Our Ref: ID 3264
Your Ref: SSD-67173718

State Significant Development Application for New Eileen O'Connor School

Thank you for the opportunity to provide comment on the State Significant Development Application (SSDA) for the proposed new Eileen O'Connor School at 84 Gavenlock Road, Mardi, the existing St Peters Catholic College site. It is understood that the proposal is for the construction and operation of a new school that will provide education and allied health facilities,¹ with **71 full-time equivalent (FTE) staff** and **200 students, children with special needs from kindergarten to Year 12**. It includes:²

FIGURE 6

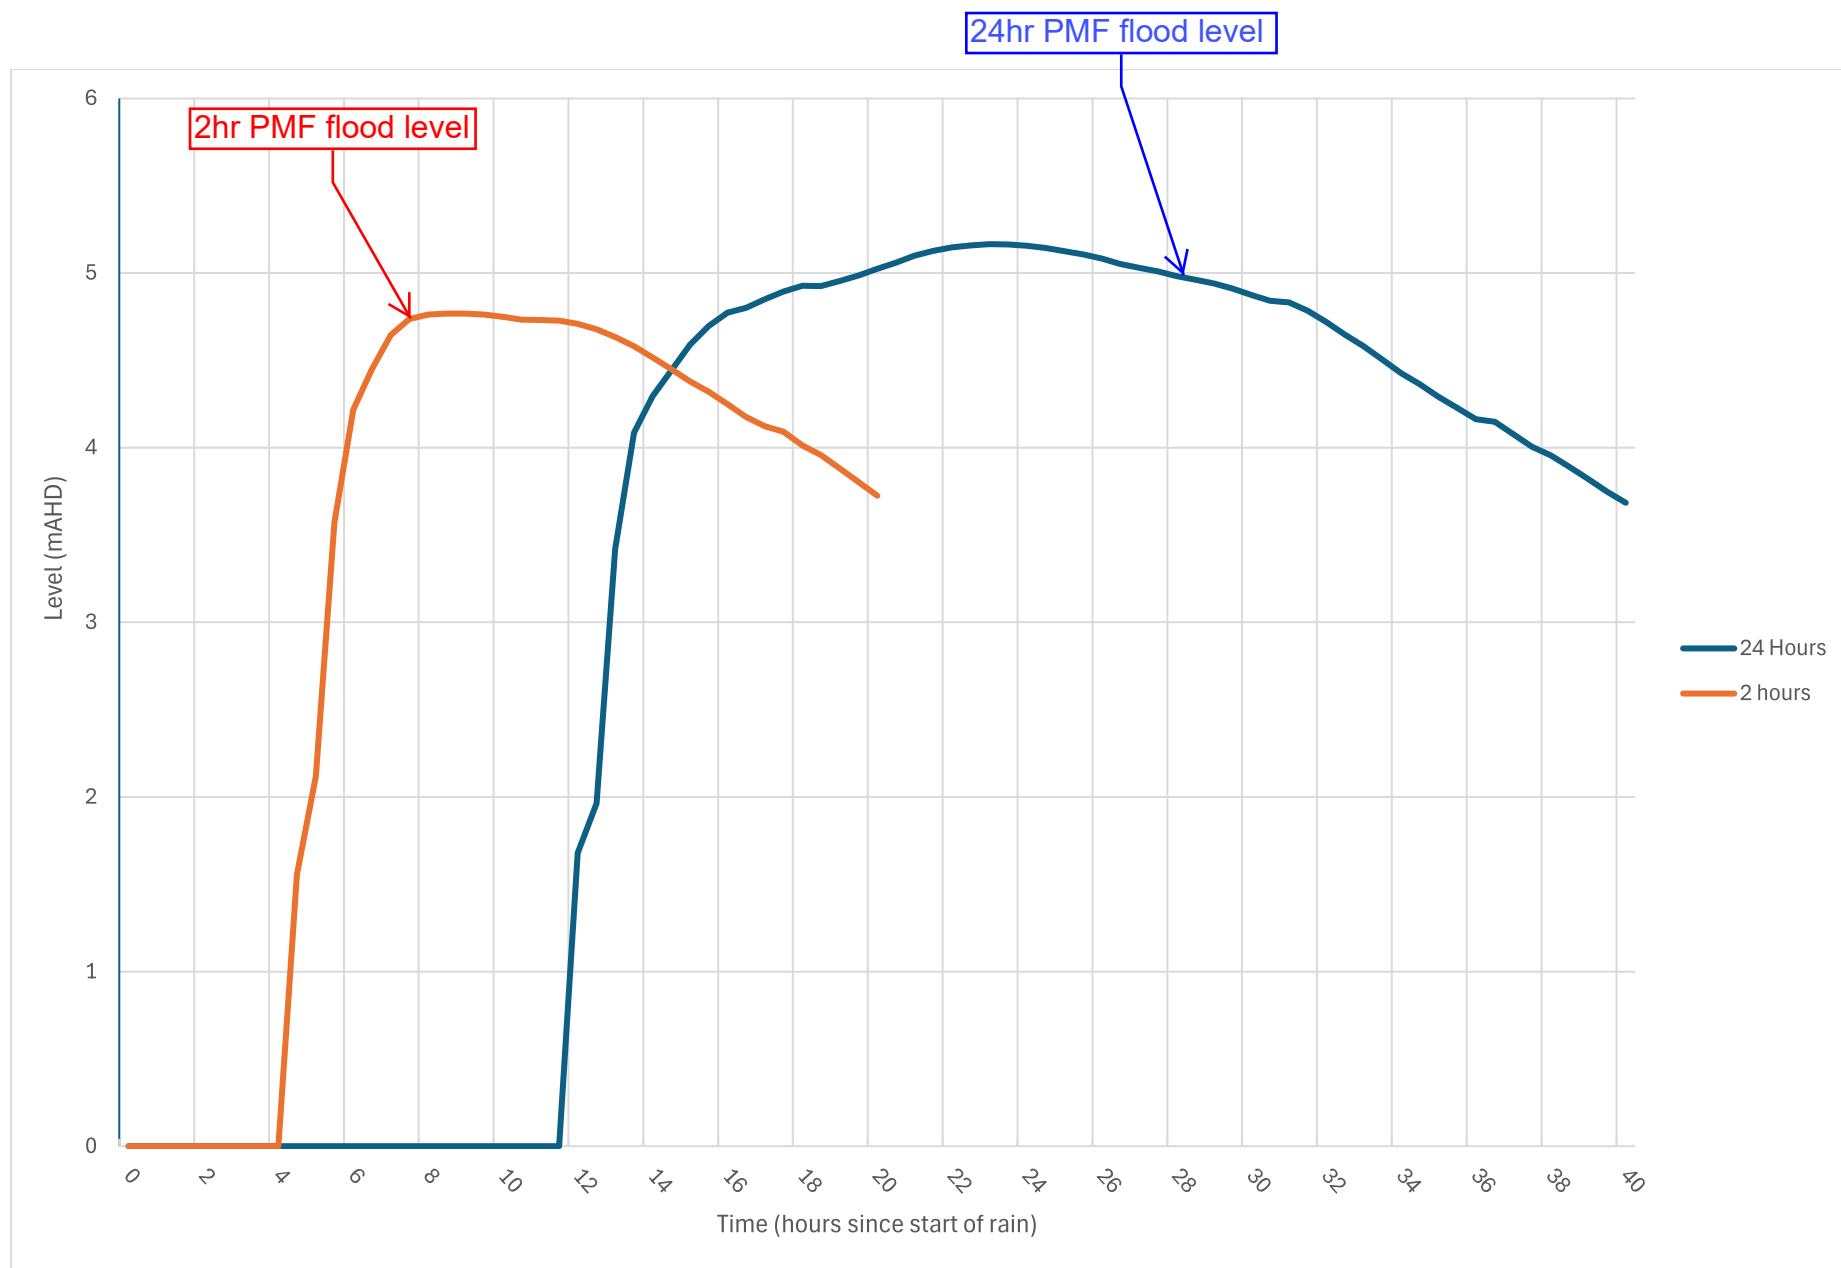
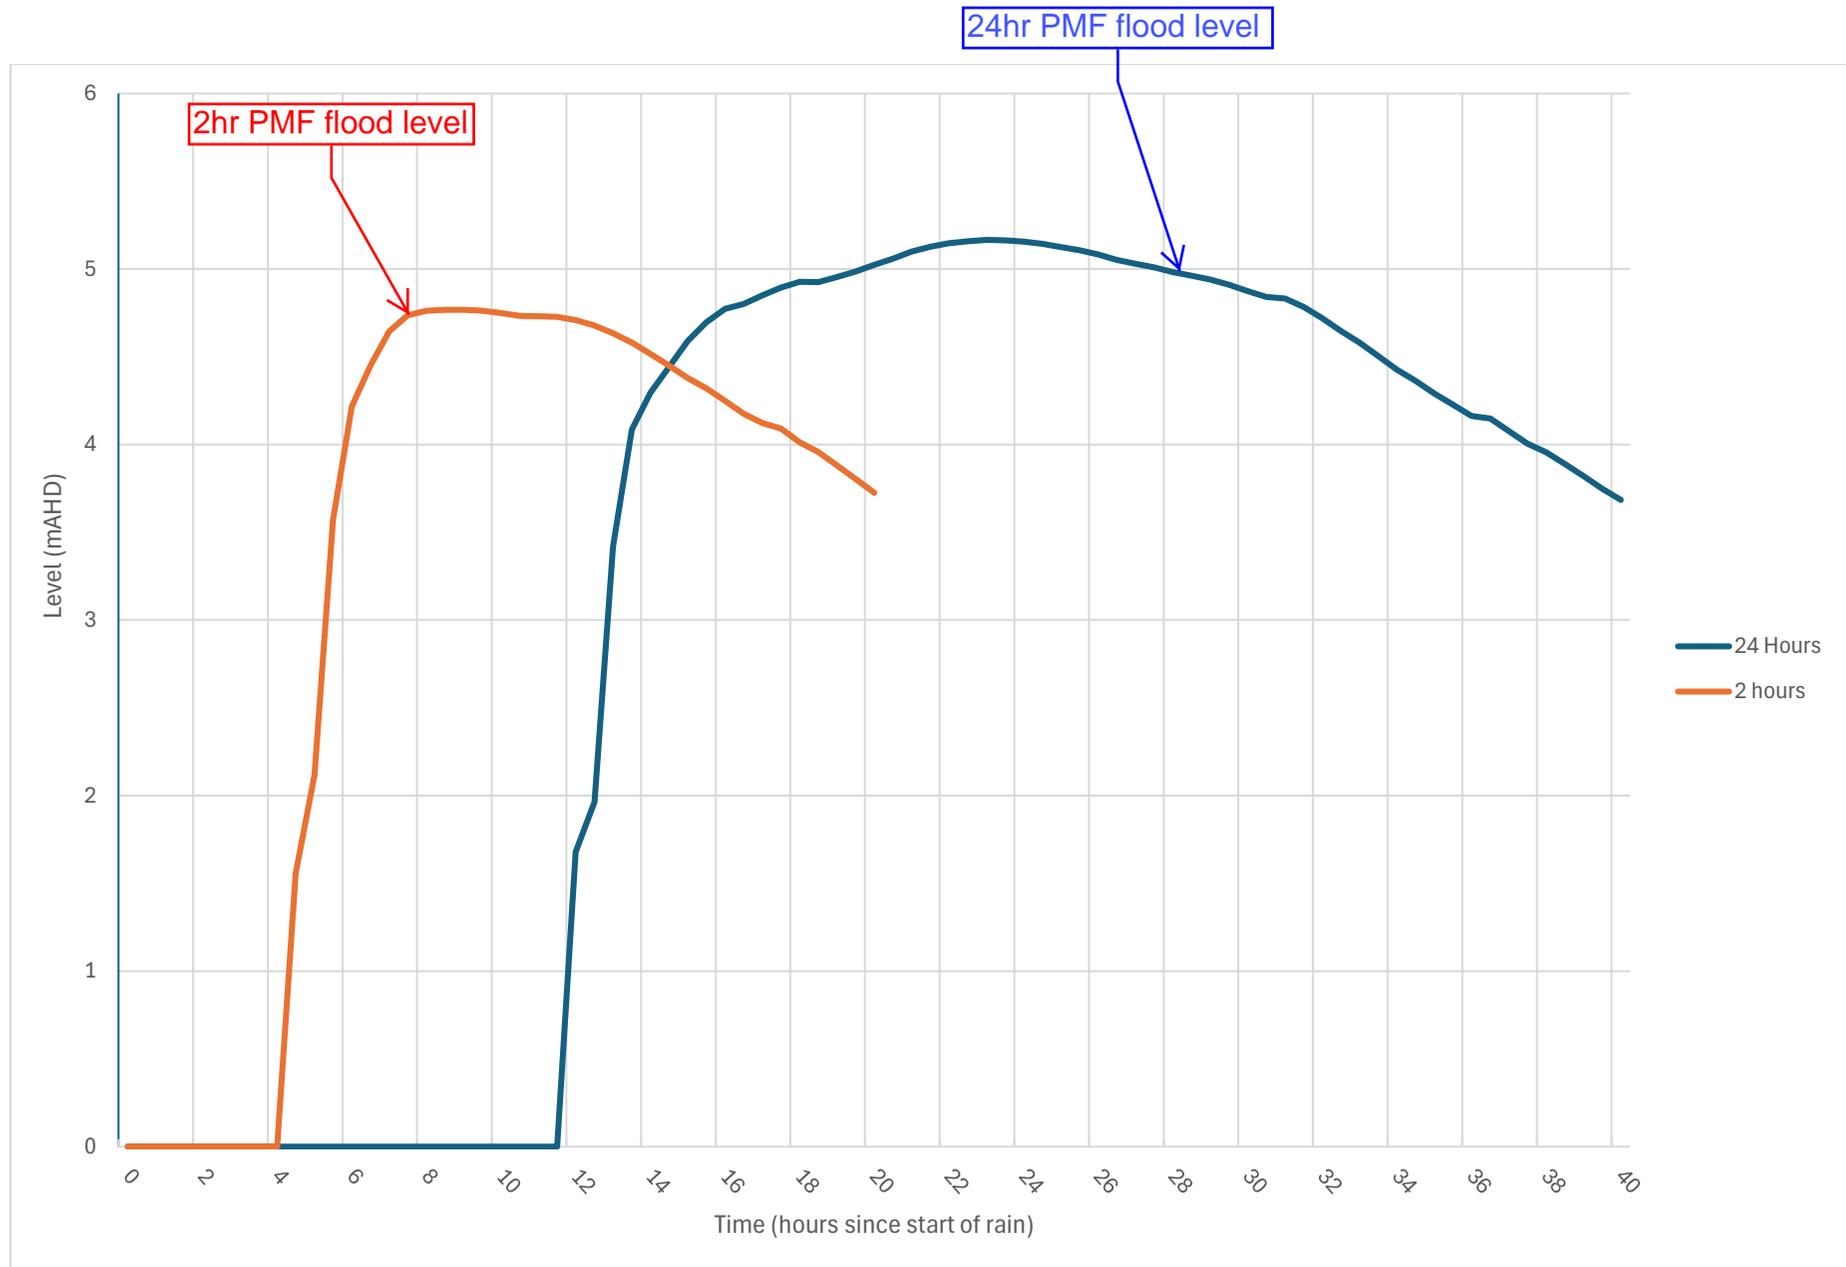
We note that the proposed route to Westfield Shopping Centre is impacted by H5 flood hazard level in a PMF event,²¹ however, noting that more frequent events were not modelled. In addition, the flood risk assessment notes that flash flooding is not the only risk present in this area, and longer duration flooding and isolation may impact the site. We emphasise that the ‘shelter in place’ strategy is not an endorsed flood management strategy by the NSW SES for *future development*. We recommend referring to the considerations in the [Shelter in Place Guideline](#) (DPHI, 2024) and considering the nature

The site is located within the catchments of Wyong River and Mardi Creek,³² with the flood impact assessment noting that the Mardi Creek catchment area is prone to flash flooding, characterised by a rapid catchment response over a short duration, while also identifying “two very different PMF floods at Wyong Bridge” gauge on the Wyong River, the 2 hours and 24 hours PMF flood – suggesting the potential for both flash flooding and longer duration flooding in the area.³³

Flood Hazard Locations along Evacuation Route to Westfield Shopping Centre

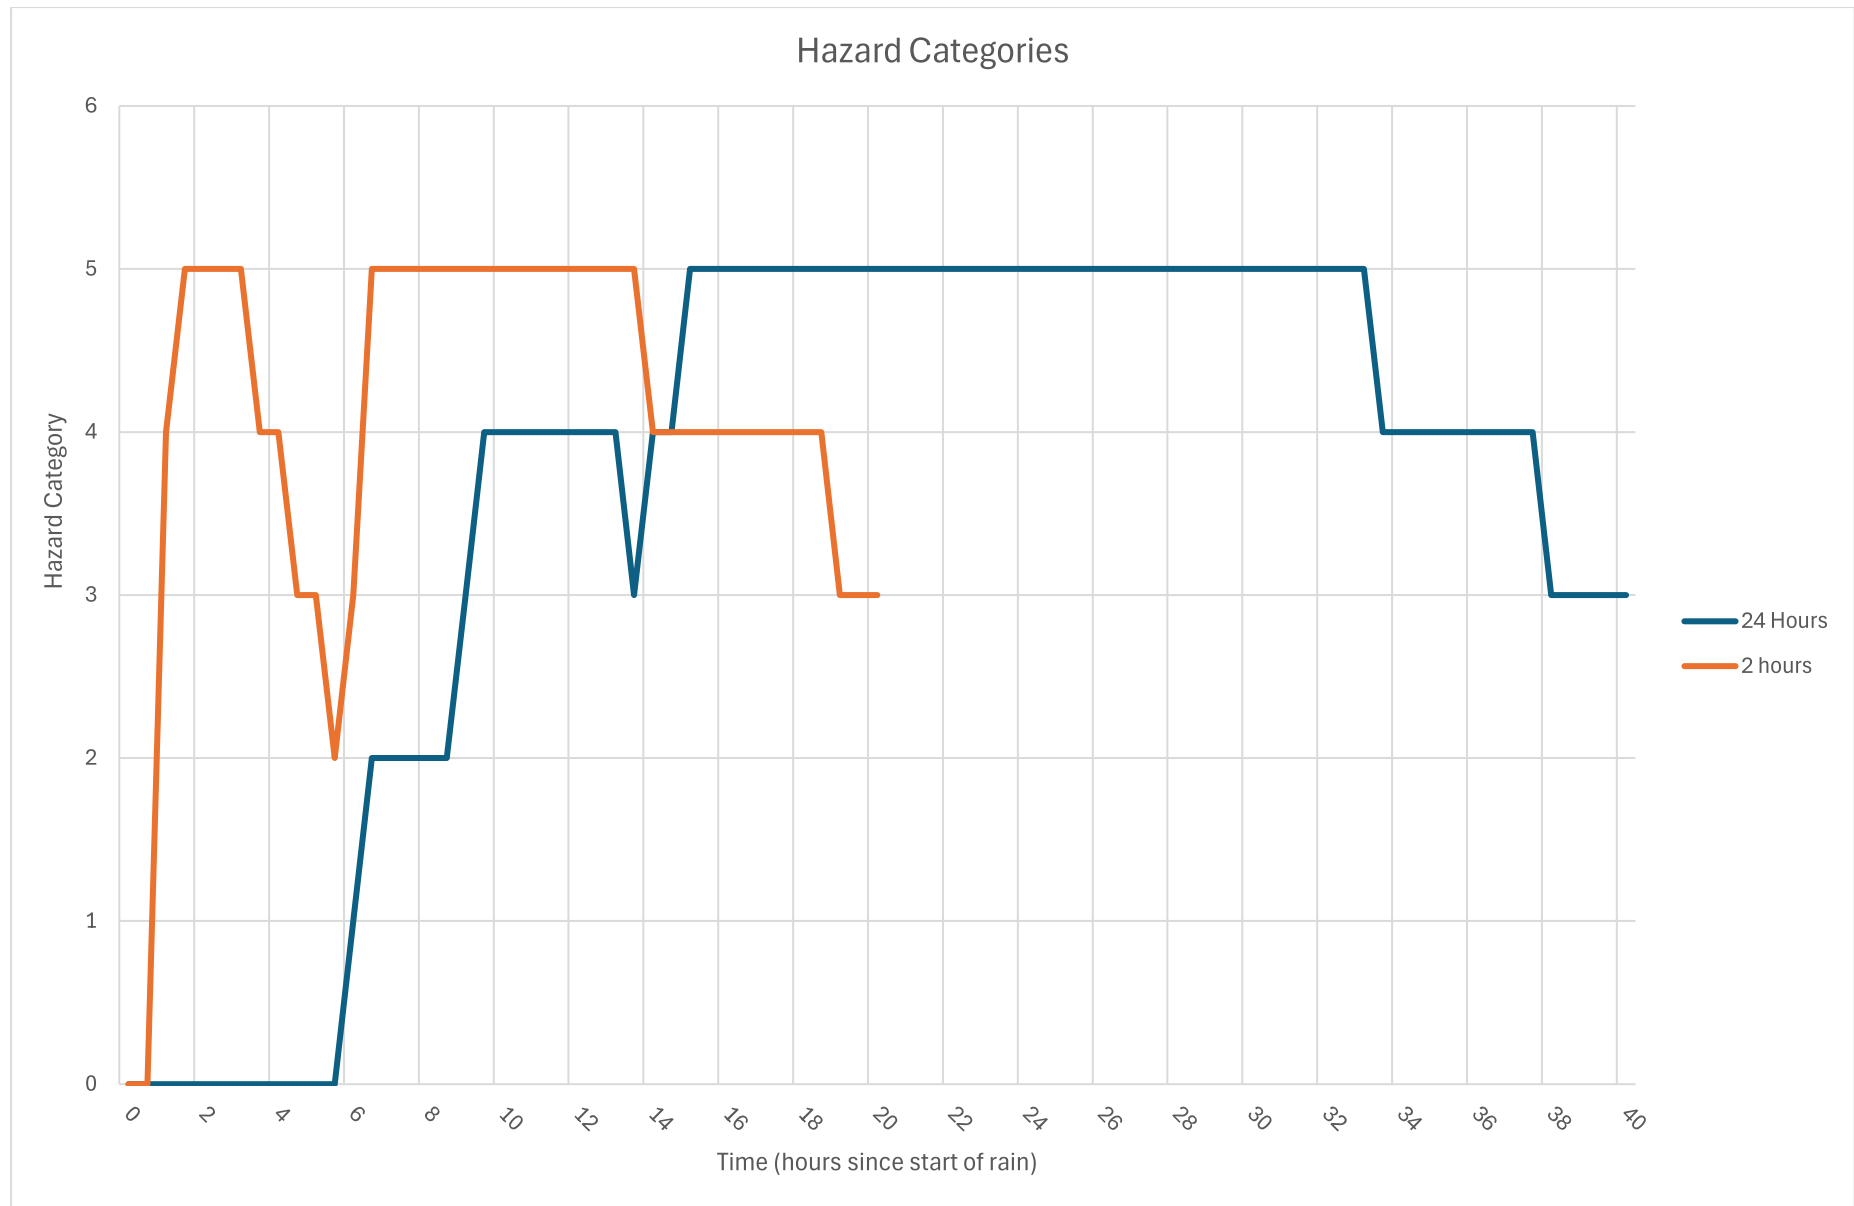
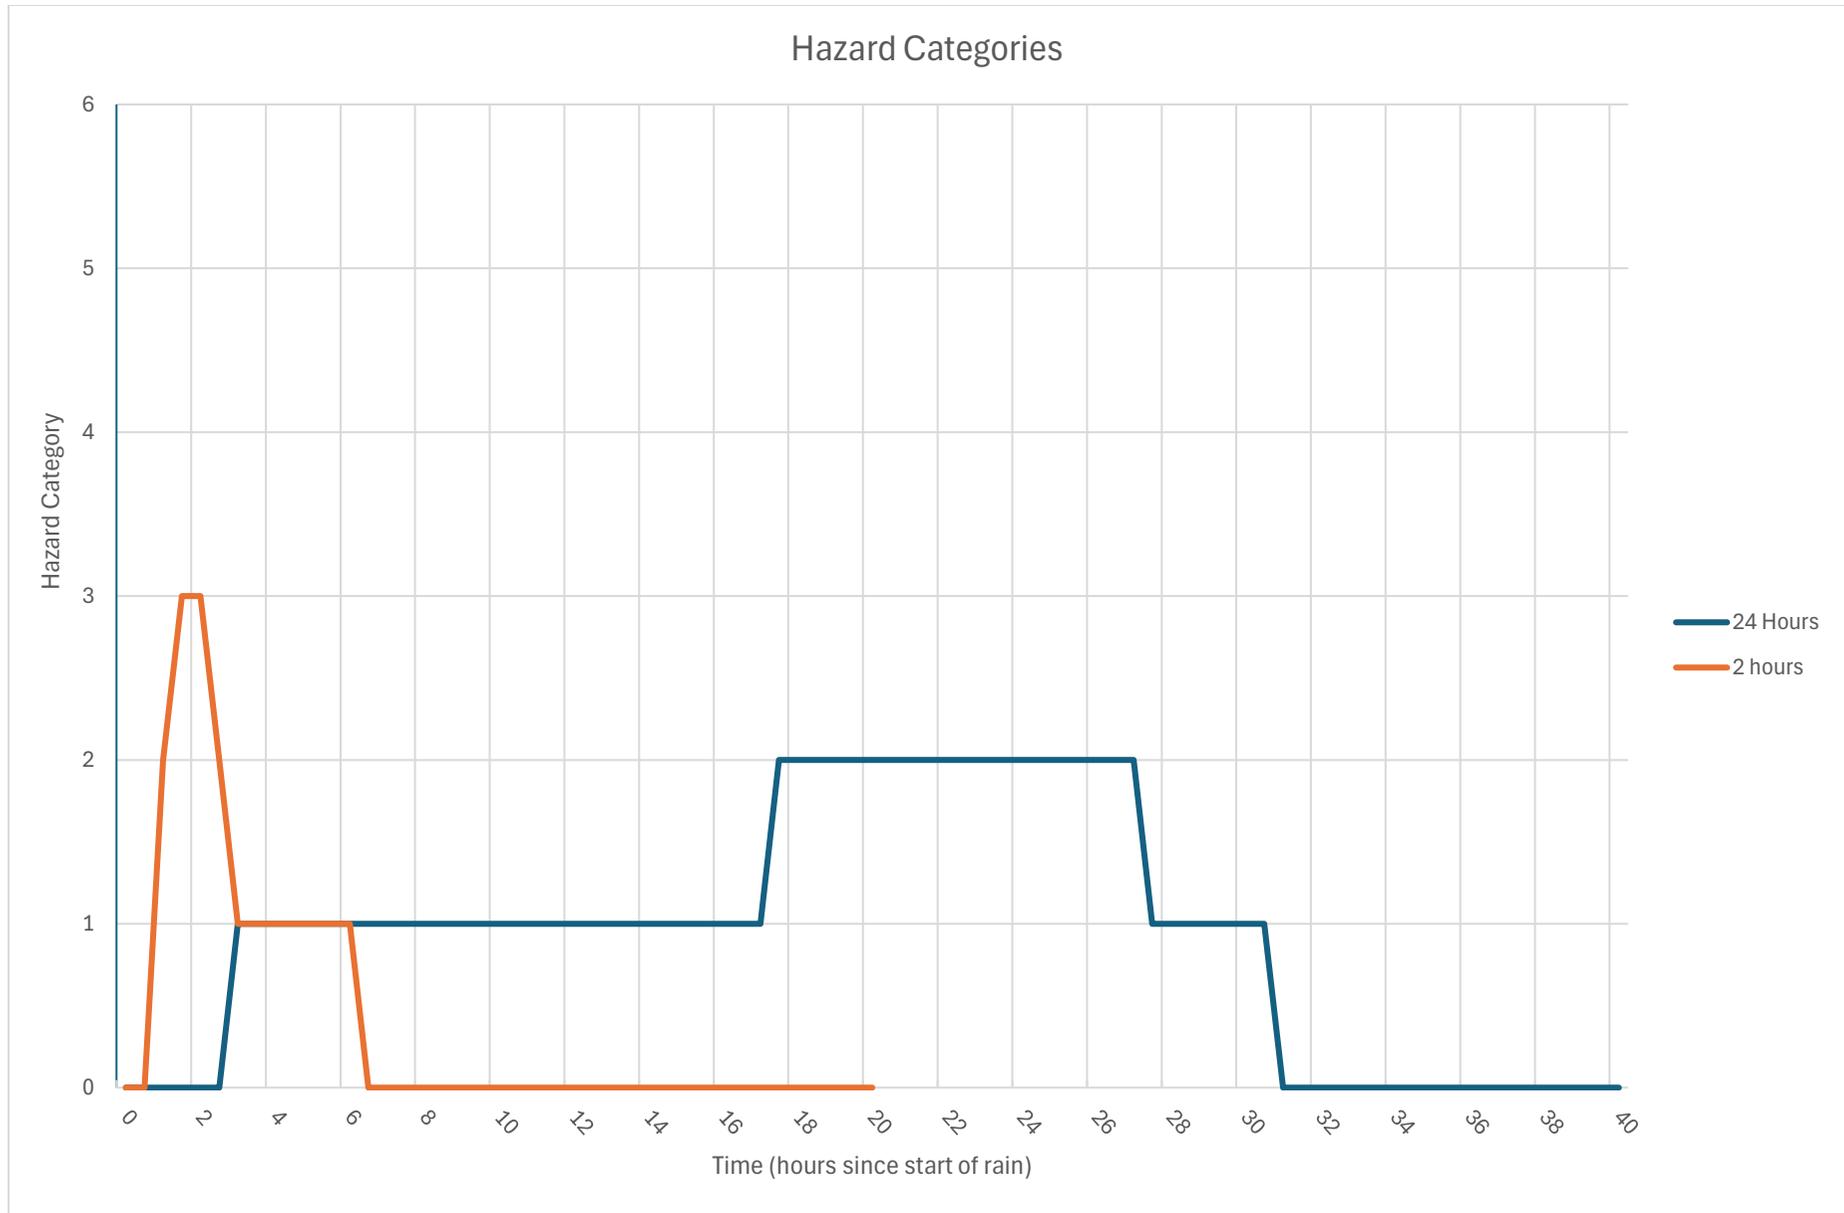
We recommend that students are able to be collected by carers rather than relying on evacuation to Westfield Shopping Centre for 200 children with *a range of physical, intellectual and emotional needs*²⁸ for the entire duration of isolation. We emphasise that the location of appropriate evacuation centres in a flood event is determined by a risk-based assessment, in consultation with the Welfare Services Functional Area and other stakeholders. Furthermore, the proposed route to the proposed evacuation location, the Westfield Shopping Centre, is impacted by H5 flood hazard level in a PMF event.
